DRB Project Number: 2022-007063
Woodmont and Paseo del Norte

SUBJECT: Site Plan

REQUEST: SITE PLAN - ADMINISTRATIVE DFT FOR A 344 UNIT MULTI-FAMILY COMMUNITY CONSISTING OF MULTI-FAMILY, TOWN HOME, AND SINGLE FAMILY DETACHED RENTAL HOMES, WITH TWO AMENITY CENTERS WITH POOLS.

Project Name: PV Trails/La Terra

**LANDSCAPE PLAN**  
 L-105

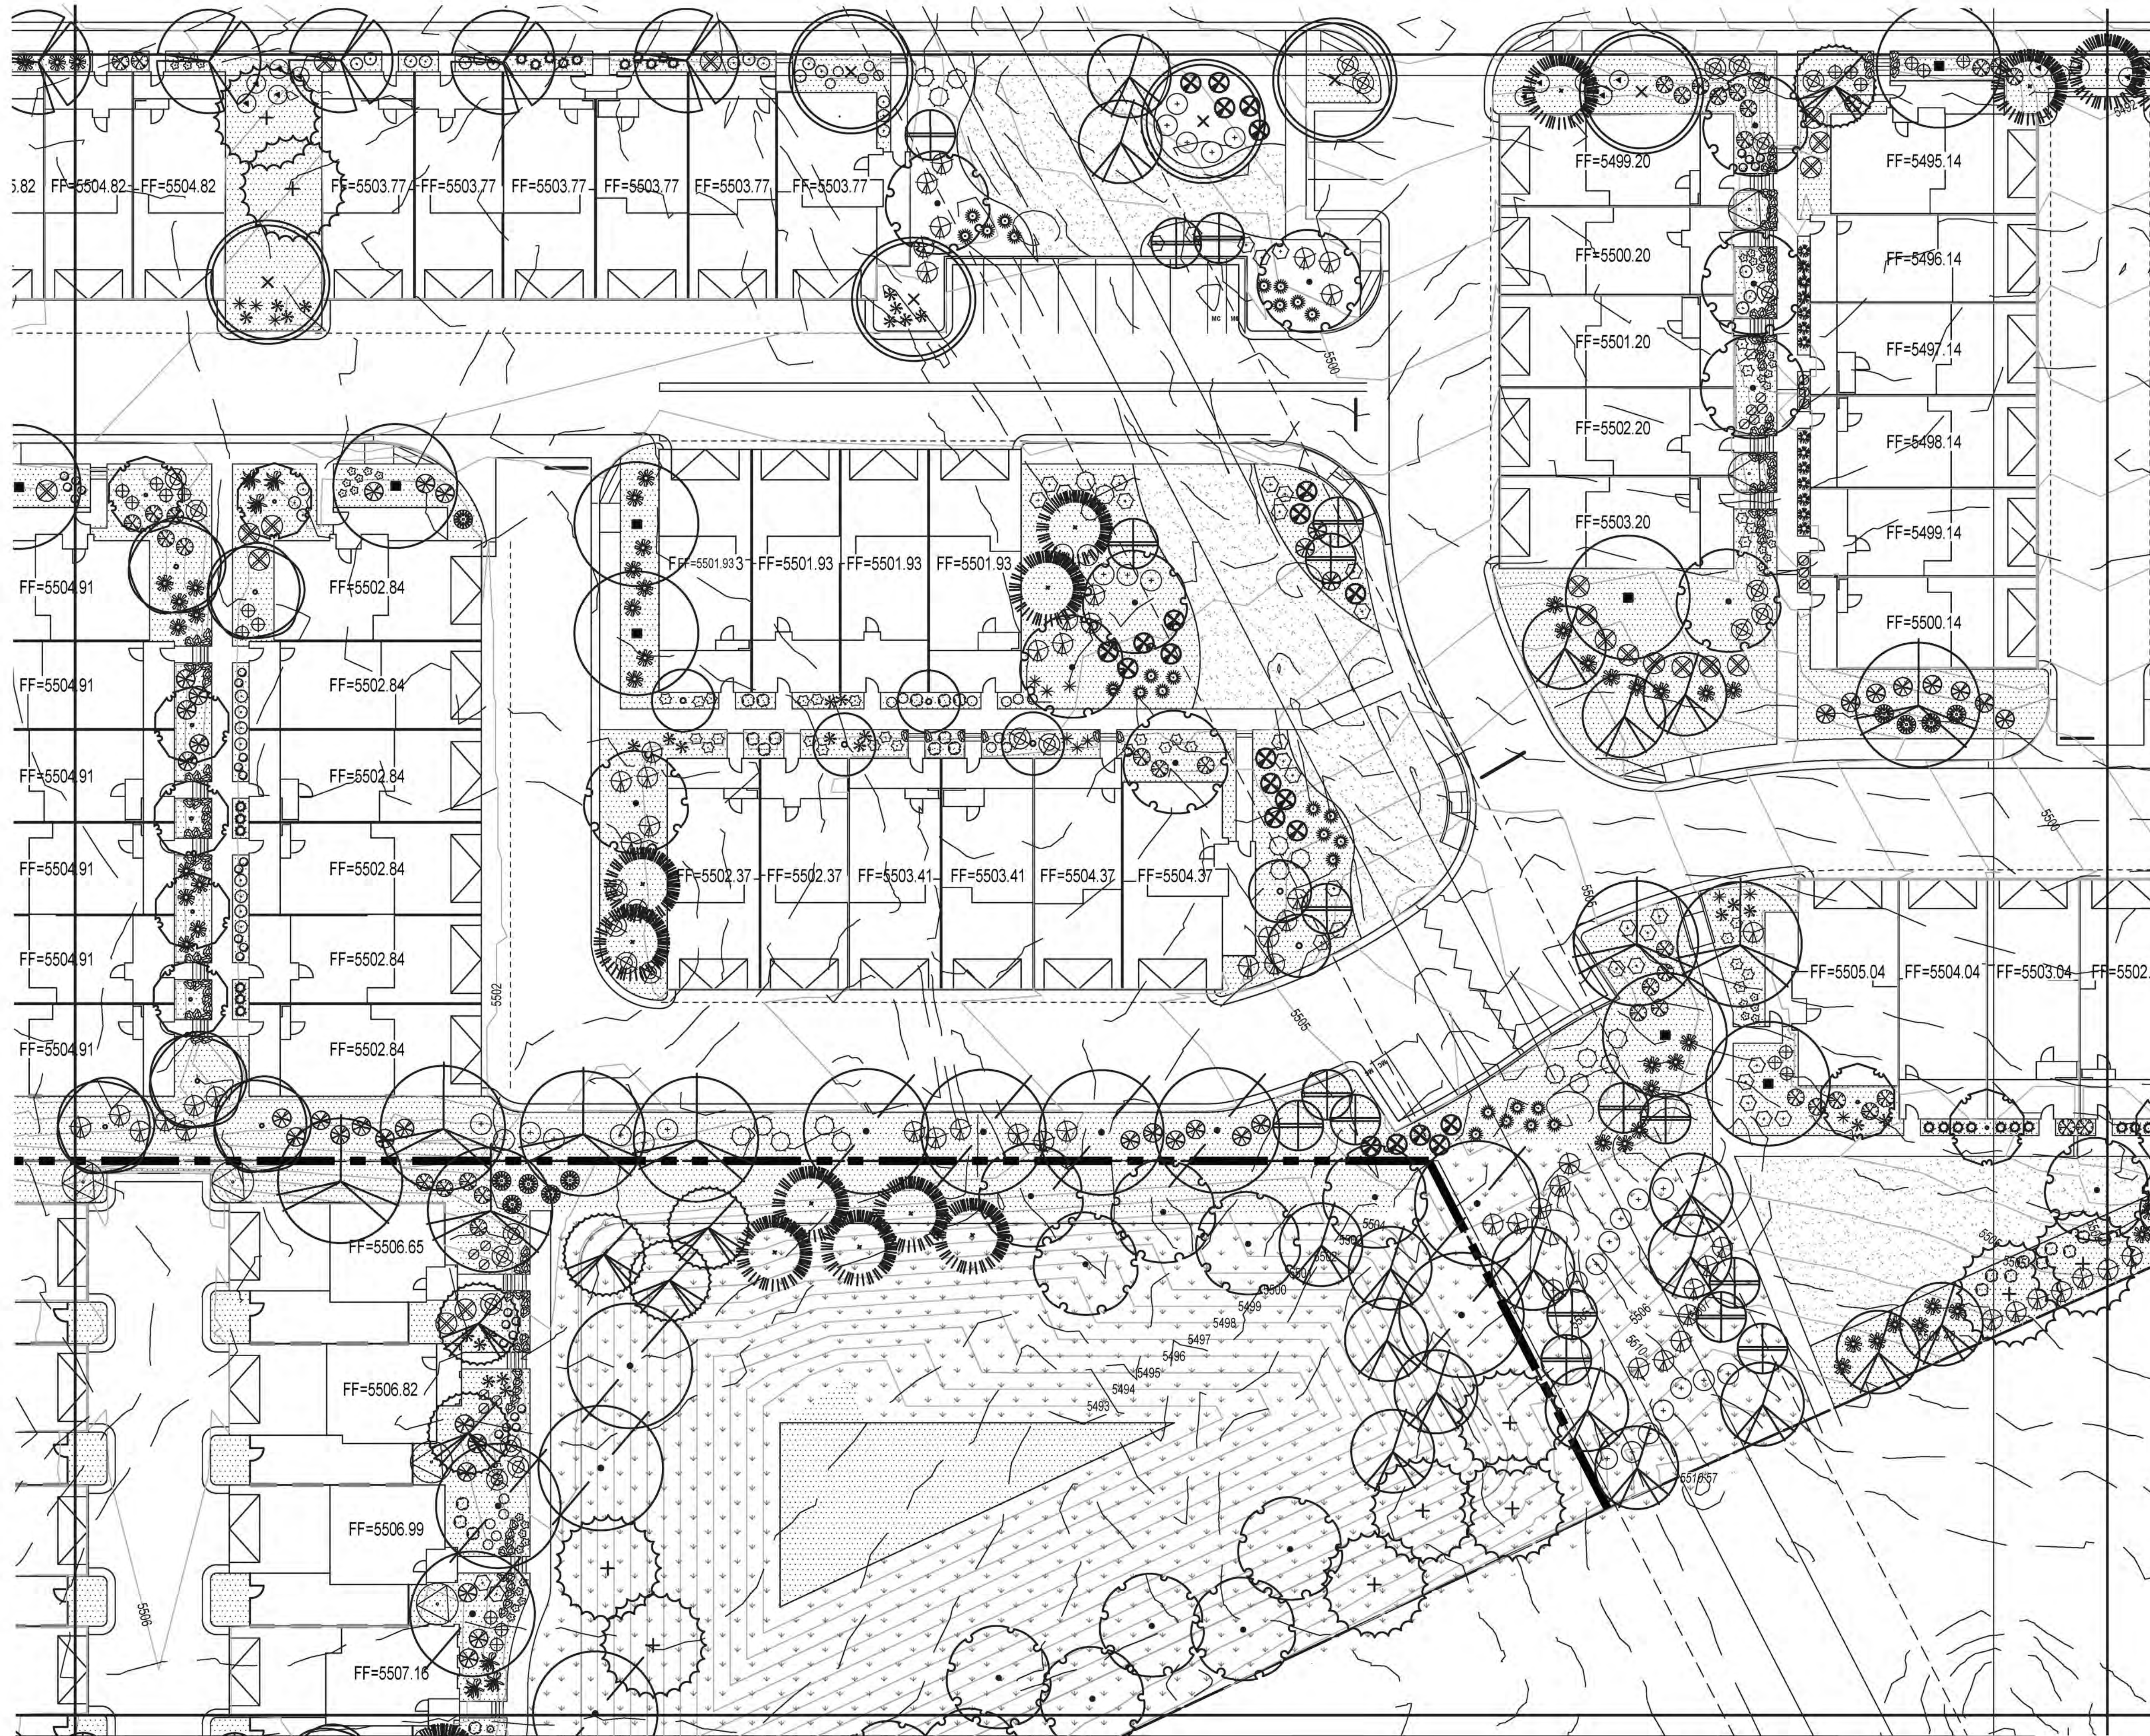
- Please provide Planting and Material Legends on all landscape sheets.
- Please provide a key plan on all landscape sheets.
- Some landscape plan sheets are not legible. Please provide a non-scanned version of all landscape sheets in your application package.

- Per 5-6(C)(10)(a) trees and shrubs shall not be planted in utility easements. **Please articulate how the proposed design meets this code.**
- Per 5-6(C)(10)(b) trees shall not be planted within 10 feet in any direction of the centerline of a sewer or water line. **Please show the sewer and water lines on the landscape plan and demonstrate how the proposed landscape complies with this code. See figure below from the IDO for your reference.**

- Per 5-6(C)(10)(f) trees shall not be planted near existing or proposed street light poles. **On the proposed landscape plan, please show existing and proposed light poles and demonstrate how the design complies with this code.**
